EP-21-0083 Crystal Park Site S-178R (Miller Residence)

The applicant proposes a single-family residence at 5050 Neeber Valley Road in the Crystal Park development. With this resubmittal, we received the Site Plan (LGA Studios, August 5, 2021) and Geologic Hazards Report (Geoquest, LLC, stamped July 7, 2021).

Submitted 9/10/2021 by Amy Crandall, Engineering Geologist, Colorado Geological Survey (303-384-2632 or acrandall@mines.edu)

Name : Final Construction - Lower Wall Stability

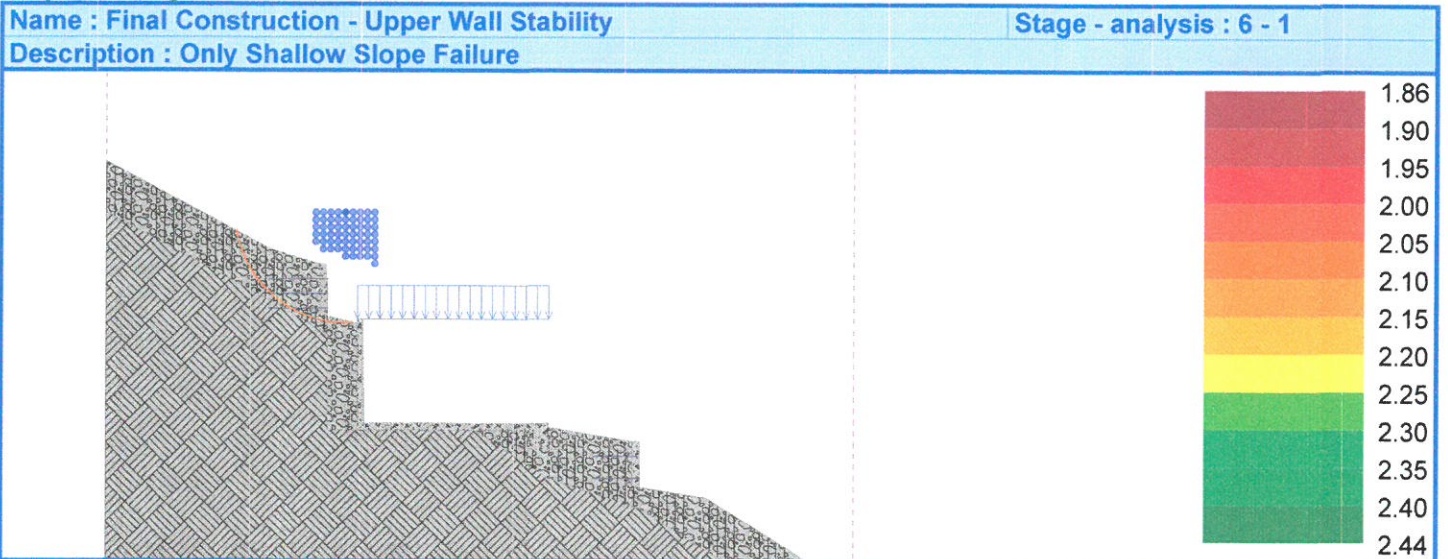
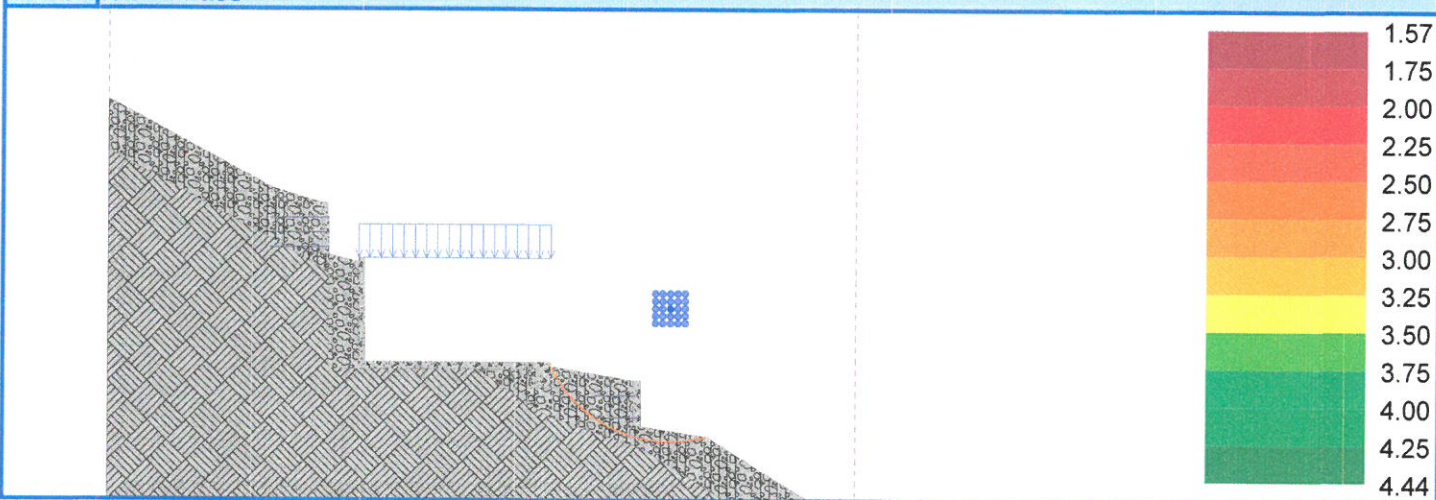
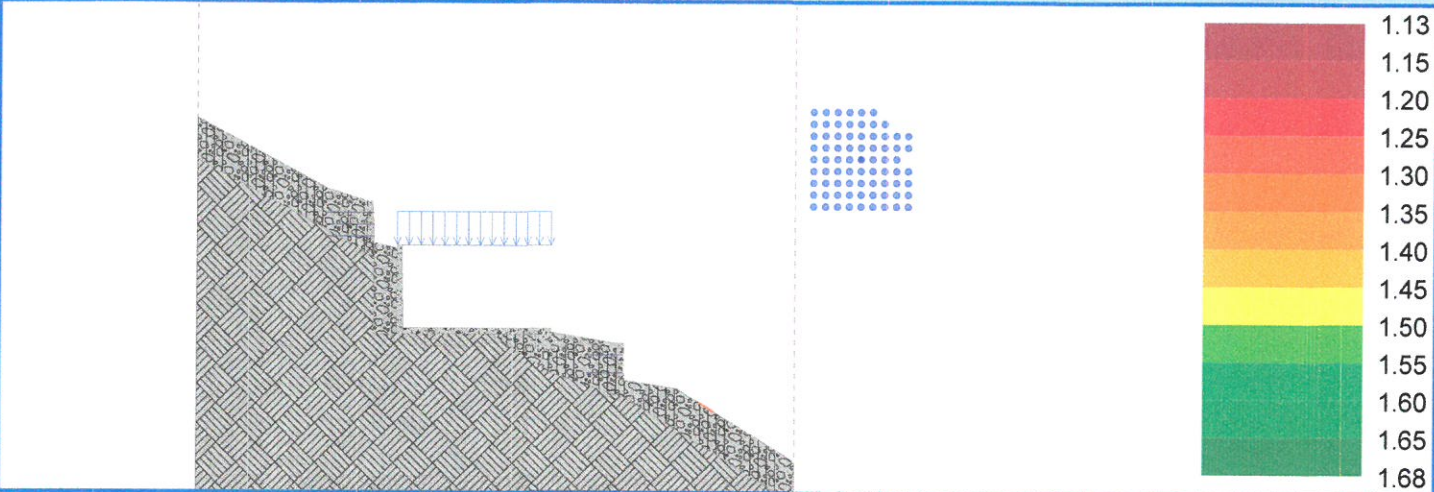
- Geoquest's analysis yielded a Factor of Safety (FOS) less than industry standards for the existing slope, maximum construction slope, upper wall stability, and downslope stability. The calculated FOS meets industry standards of 1.5 for the lower wall stability and final construction – global slope stability. It is unclear whether Geoquest's analysis uses measured soil strength values from direct shear testing or if the strength values were obtained from assumed values. The Geoquest subsurface investigations are shallow (15 feet), and bedrock was only encountered in one of the test holes (Soils Report, Geoquest, LLC, stamped December 28, 2017). No seismic factors were included in the analysis, even though the site is within 0.5 miles of the Ute Pass Fault zone. Also, there is little text describing the methods, reasoning, and result of the analysis.

- **Shear strength values should be measured from site-specific samples and lab testing;**
 - **Text is provided that explains the slope stability analysis results presented; and,**
 - **Seismic factors are included in the analysis, if not already.**
3. *Driveway retaining walls, building foundations, and upslope walls that will function as retaining walls must be designed by a qualified geotechnical or civil engineer and must include adequate behind-wall drainage.*
 - As recommended by Geoquest, "Retaining walls should be designed by a qualified geotechnical engineer." Also, "The retaining wall designer should check for local and global slope stability." The recommendations we provided above for the slope stability analysis should also be applied to the retaining wall design.

SITE PLAN
SCALE: 1" = 20'

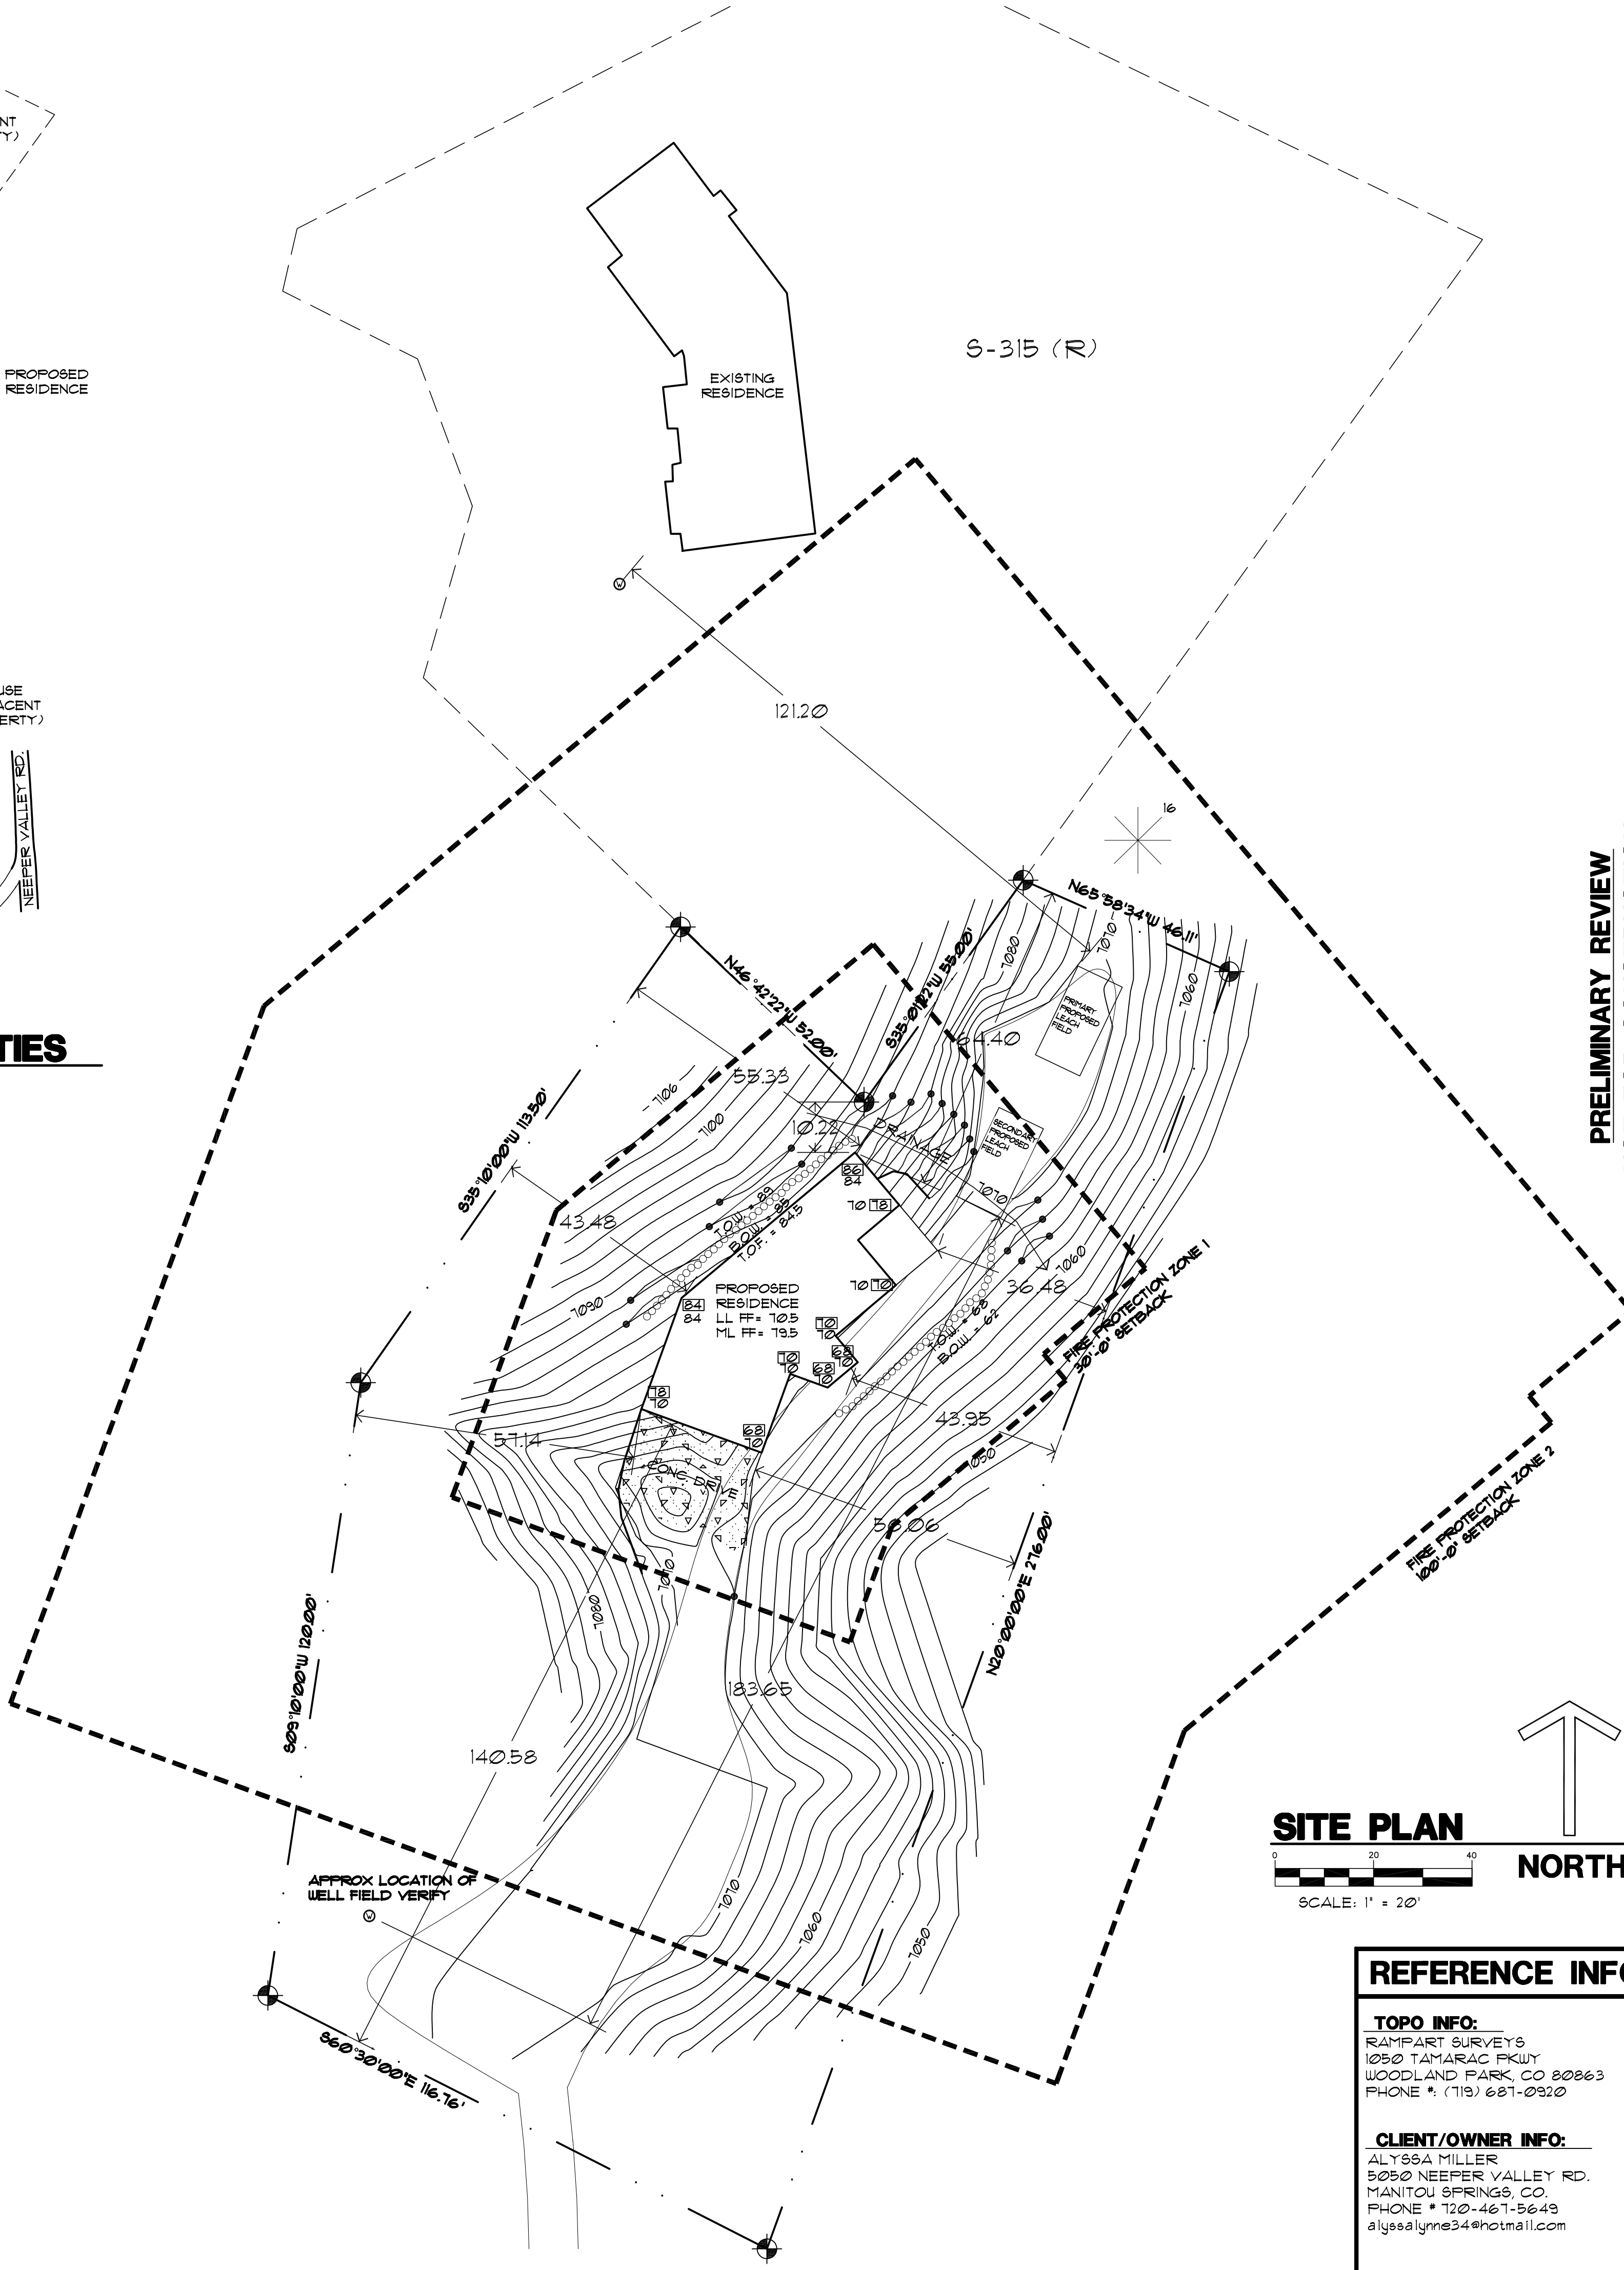
1. *A qualified geotechnical professional should determine maximum allowable, unretained temporary, and permanent cut/fill heights and slope angles.*
 - As noted on page 2 of Geoquest's geologic hazard report, "we recommend slopes not exceed 2:1 (horizontal:vertical). Slopes steeper than this are subject to localized slope failure." However, it appears that these slopes are exceeded in the slope stability analysis with local slope failures shown. Recommended slope angles should be noted in the site plan.

- CGS agrees with Geoquest, “Disturbed soils should be revegetated and protected with erosion control blankets until the seed takes hold.” CGS recommends that erosion control measures are shown in the plans. Site grading should direct water away from the structure.

1. **Proposed slope angles should be included in the site plan.**
2. **The provided slope stability analysis include:**
 - **Shear strength values measured from site-specific samples and lab testing;**
 - **Text that explains the slope stability analysis results presented; and,**
 - **Seismic factors.**
3. **Retaining walls should be designed by a qualified geotechnical engineer and include both global and local slope stability analysis.**
4. **The project civil engineer design a drainage system that protects the subject property and properties further downslope from the flow of surface-generated water.**
5. **Erosion control protection is included in the site plan.**
6. **Foundation excavations are inspected for evidence of fractures, discontinuities, and weathered zones during the open hole observations.**
